Document DCO 1.8

Application Documents Tracker

The East Midlands Gateway Phase 2 and Highway Order 202X

APPLICATION DOCUMENTS TRACKER (DOCUMENT DCO 1.8)

ACTIVE TRAVEL LINK (SECTION A) LONGSECTION
SCALE: H 1:2500, V 1:500. DATUM: 85.000

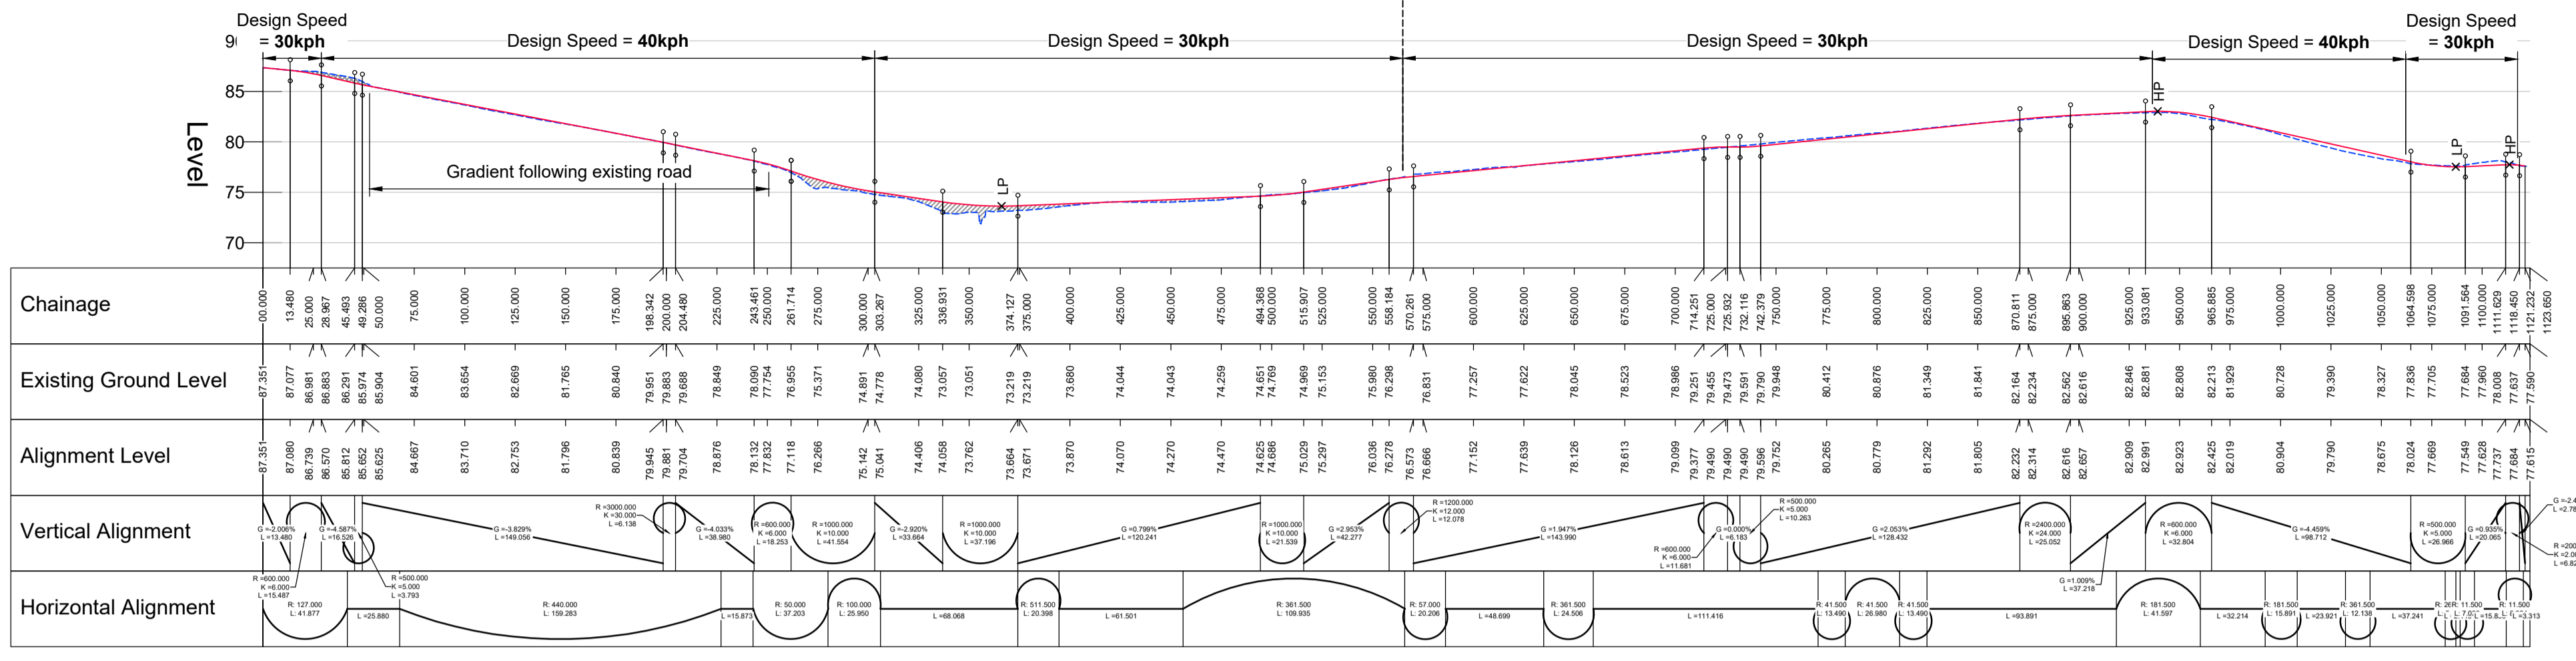
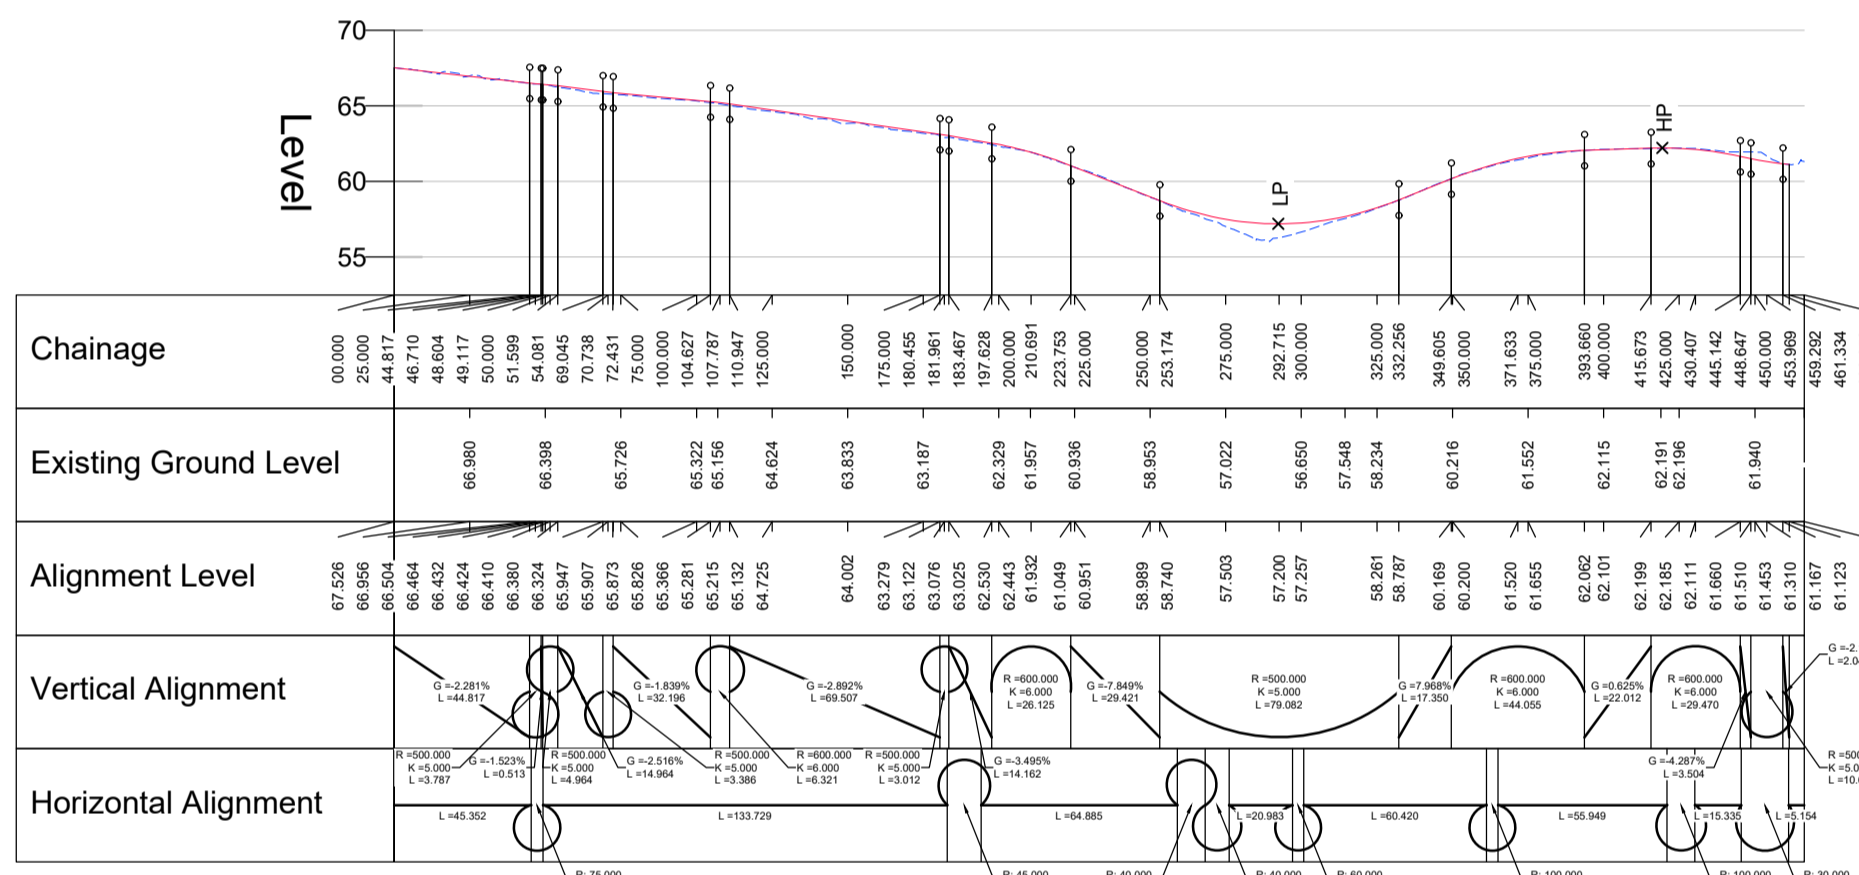
No.	Document updated since Deadline 3	Summary of Change to Document	Reason for Change to Document
			[REP2-046] [REP3-058]
9.	Highway Plans Long Sections Sheet 3 DCO 2.10C [APP-051D]	Amendment to reflect the revised alignment of the Active Travel Link.	The Applicants have agreed to make this change in response to the Deadline 2 and Deadline 3 submissions made by Leicestershire County Council. [REP2-046] [REP3-058]
